EL PASO COUNTY GRADING AND EROSION CONTROL PLAN CHECKLIST

EPC Project Number: **SF2427**

GRADING & EROSION CONTROL PLAN
COVER
SHEET CV 1
PCD FILE NO.: SF2427

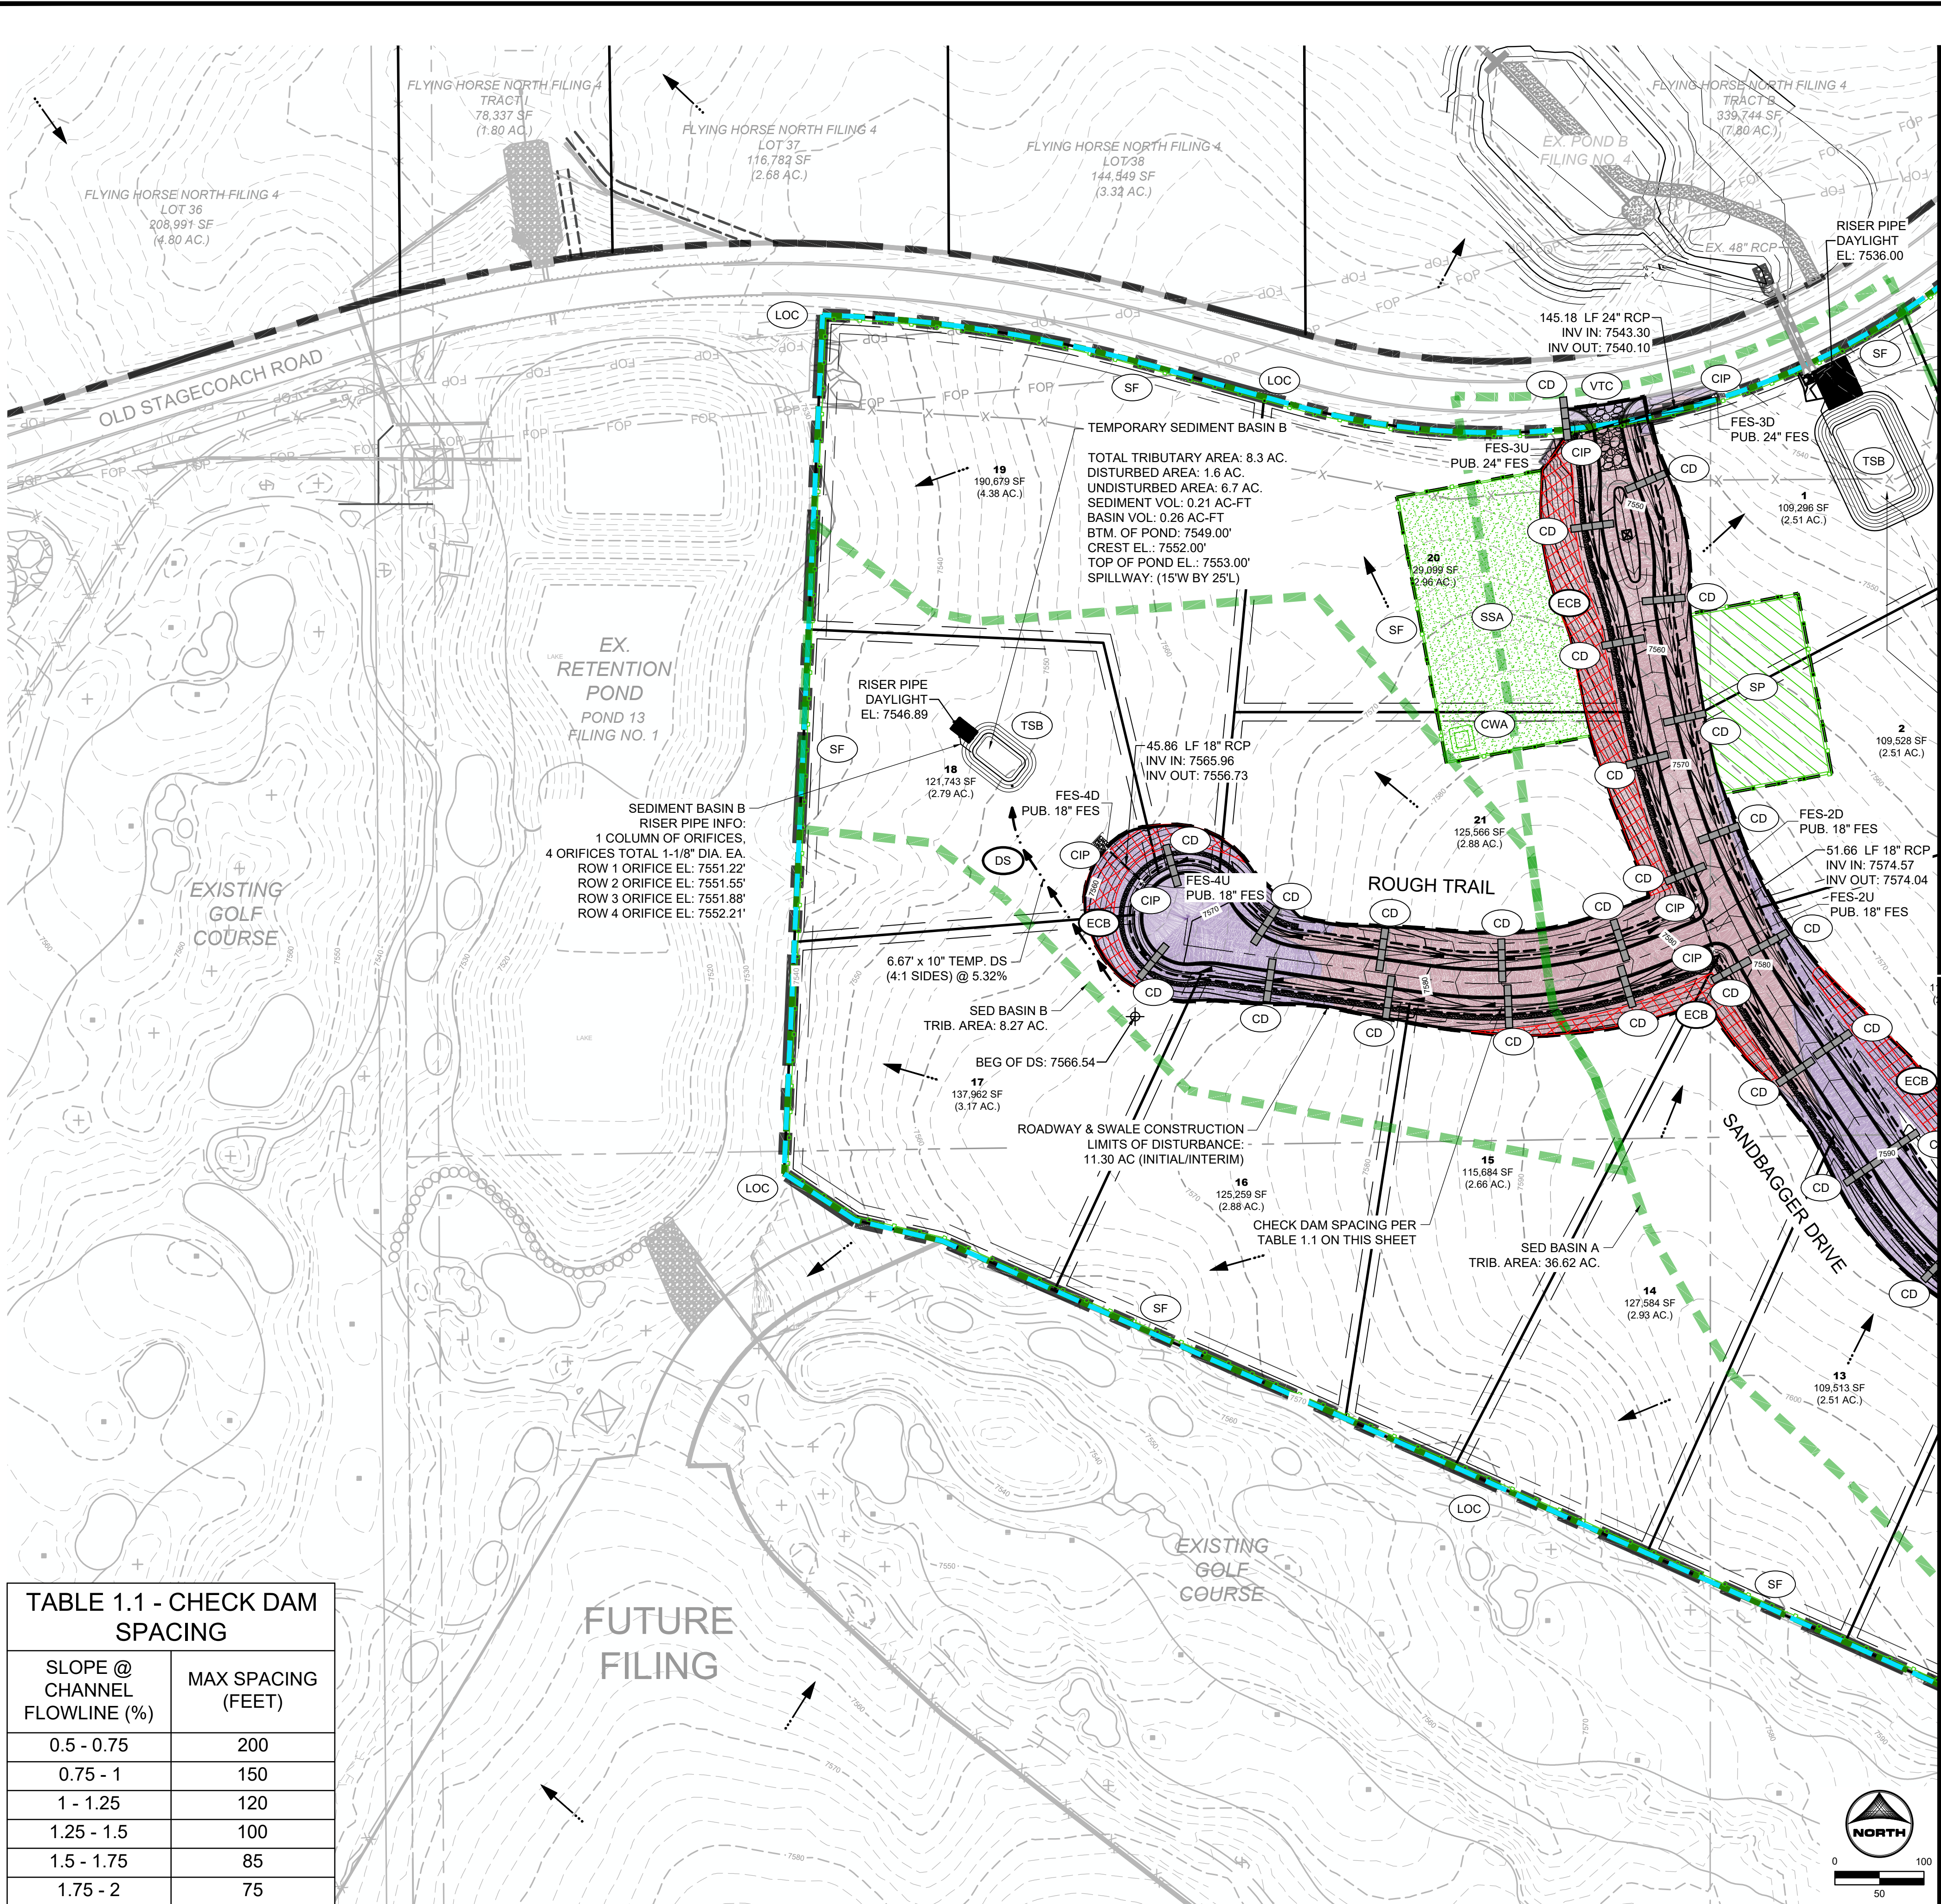
Are the two off-site ponds not under the direct control or ownership of the Owner or Operator? If so an agreement between the two entities should be provided. Otherwise, put N/A.
